CITY OF ALBUQUERQUE

May 11, 2022

Re: Slim Chicken - Albuquerque
8240 Montgomery Blvd NE
Traffic Circulation Layout
Engineer's Stamp 05-02-2022 (G19-D004E)

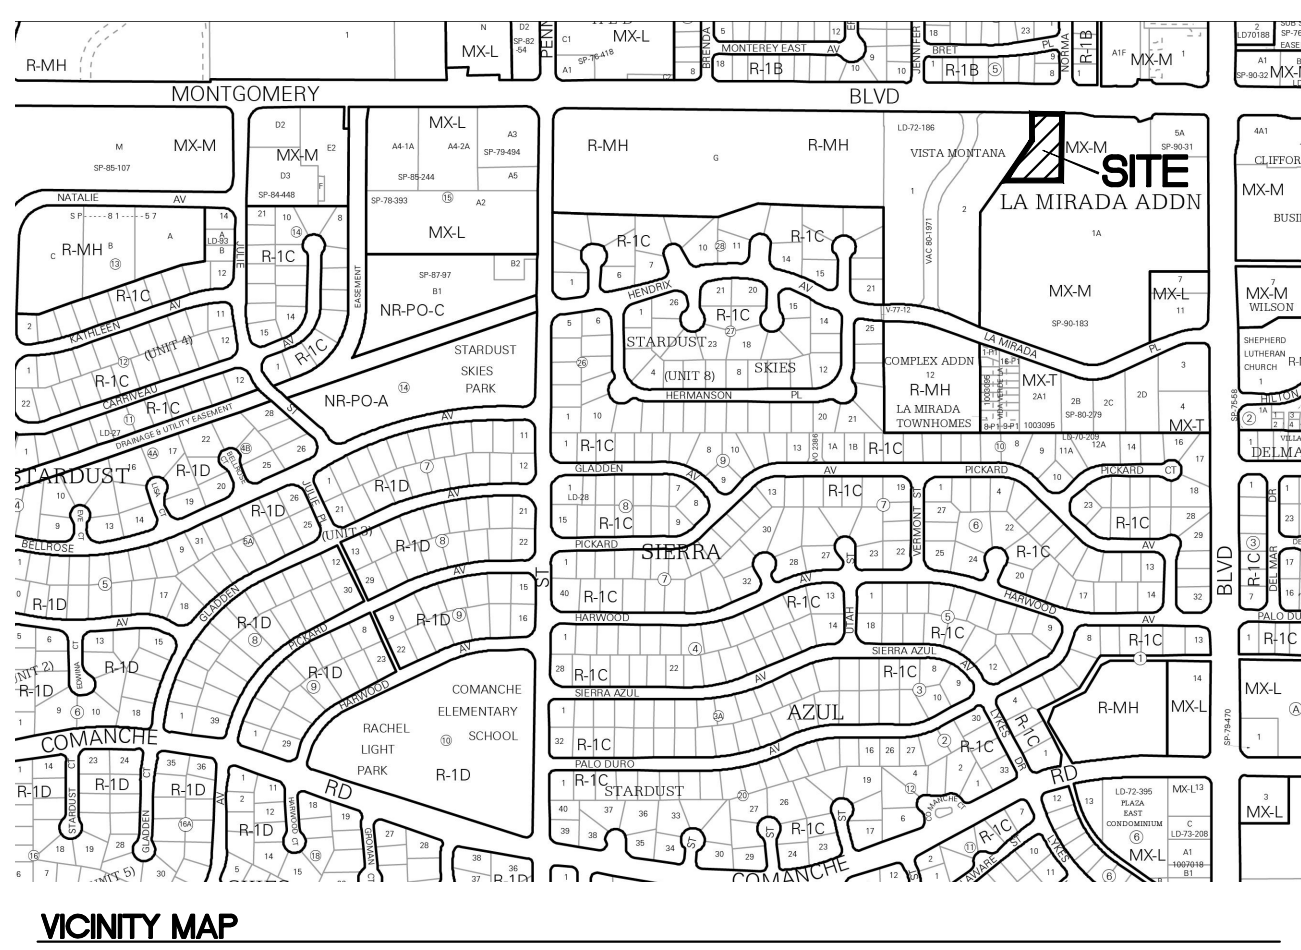
1. Listed are the number of parking spaces required by the IDO as well as the proposed number of parking spaces including bicycle and motorcycle parking.
Coordinate/discuss with Zoning.

2. **The proposed Work Order-CN 568483:** Please provide what is being constructed on the drive aisle, missing portion sidewalk (Western portion of entrance drive aisle). This work order and possibly infrastructure list will need to be provided prior to TCL approval. Why is there an angle of the main drive aisle off Montgomery? Explain, easement will be needed or is there a new plat being proposed. The concern is most of the drive aisle is being located on adjacent property. Is this a concern for future developments? Please address?

3. **Montgomery Entrance:**
 - The existing ADA curb ramp must be updated to current standards and have truncated domes installed. Please verify because it appears that it isn't **(per Field inspection- 5/11/2022)**.

- Verify the ramp is multi-directional to service ADA pedestrian pathway.
 - **Keyed Note 4:** Verify that this 6 ft concrete sidewalk/pedestrian pathway is ADA accessible from public sidewalk to building entrance (5% max longitudinal/ 2% max cross slope).

- Provide driving lanes dimensions onto site. Are the pavement directional arrows and lane striping existing or proposed? If proposed please provide details and label each.

- Do you need to provide new c&g on the western portion of drive aisle coming of Montgomery entrance? If so, please provide notes to substantiate the new curbing with the new sidewalk (Keyed Note 4) around the parameter of the proposed development. Are you also construction the eastern portion of this drive aisle infrastructure? If so, provide notes to construct this portion of the drive aisle infrastructure. If not, then ignore this comment.

- Internal drive aisle: Where is the sidewalk conductivity to all sites from this proposed site development. Please address this concern.
4. Identify the right of way width, medians, curb cuts, and street widths on Montgomery Blvd.

5. **Keyed Note 1:**
 - Provide parking barriers in front of ADA parking stalls to avoid vehicle hitting ADA signage and avoid tripping over proposed ramps.

- Please height of sign post from ground elevation to bottom of first sign plat.
 - You are referencing Sheet SP-21, do you mean SP-2? Please clarify.
 6. **Keyed Note 2:** Please reference detail on sheet SP-2.

7. **Keyed Note 5:** Verify that sign post height is legal height for signage on proposed detail sheet SP-2.
 8. **Keyed Note 8:**
 - You show pedestrian crossing but no ramps an/or to accommodate other than landscaping with sidewalk.

- No sidewalk connections is shown for this pedestrian crossing, please explain the purpose of this crossing.
 - Provide the striping detail.
 9. **Keyed Note 10:** I couldn't find this on site plan. Do you need this note? Yes or No?

10. The ADA access aisles shall have the words "**NO PARKING**" in capital letters, each of which shall be at least one foot high and at least two inches wide, placed at the rear of the parking space so as to be close to where an adjacent vehicle's rear tire would be placed. (66-1-4.1.B NMSA 1978). **Provide pavement marking detail for proposed text 'No Parking'.**

11. List radii for all curves shown; for passenger vehicles. Radius for delivery trucks, fire trucks, etc. is 25 ft. or larger. **All internal radiuses will need to be 15 ft minimum especially on the drive thru lane.**

12. Parking areas shall have barriers to prevent vehicles from extending over sidewalk.
 13. **Proposed Dumpster:**
 - Provide a letter from adjacent property owner stating that it is okay to have Dumpster located outside the lot of proposed development.

14. Fire Department: An approval Fire 1 plan needs to be provided.
 15. It is not apparent what type of pavement surface is being proposed. A hard driving surface will be required as part of this proposed project for parking area and drive aisles.

16. What is the proposed queuing for the drive thru lane? Please provide and an analysis to ensure that the queuing doesn't back onto the drive aisle, main entrance aisle and Montgomery Blvd. Do you need to delineate the drive aisle lane and drive thru lane to avoid any blockage of drive aisle for parking lot circulation?

17. The drive thru lane exits onto main drive aisle and a possible traffic movement conflict will be created by this proposed design. Please explain your strategy versus traffic conflict with the opposing traffic coming thru this drive aisle.

18. All one-way drives shall have "One Way" and "Do Not Enter" signage and pavement markings. **Please show detail and location of posted signs and striping.**

19. The minimum drive through lane width is 12 feet with a 25 foot minimum radius (inside edge) for all turns. (A 15 foot radius can be used with an increase in lane width to 14 feet). Please dimension all lane widths and radii.

20. Drive thru lane: In the middle there appears to be an island or is it striping? Please label and provide detail.
21. Please provide a sight distance exhibit at Montgomery entrance frontage.

22. Show the clear sight triangle and add the following note to the plan: "Landscaping and signage will not interfere with clear sight requirements. Therefore, signs, walls, trees, and shrubbery between 3 and 8 feet tall (as measured from the gutter pan) will not be acceptable in the clear sight triangle.

23. Shared Site access: driveways that straddle property lines, or are entirely on one property but are to be used by another property, shall have an access easement. Please include a copy of your shared access agreement with the adjacent property owner.

24. Unused curb cuts must be replaced with sidewalk and curb & gutter. A build note must be provided referring to the appropriate City Standard drawing (2430 & 2415A) **on Montgomery (if applicable).**

25. Add a note stating "All broken or cracked sidewalk must be replaced with sidewalk and curb & gutter." A build note must be provided referring to the appropriate City Standard drawing (2430 & 2415A).
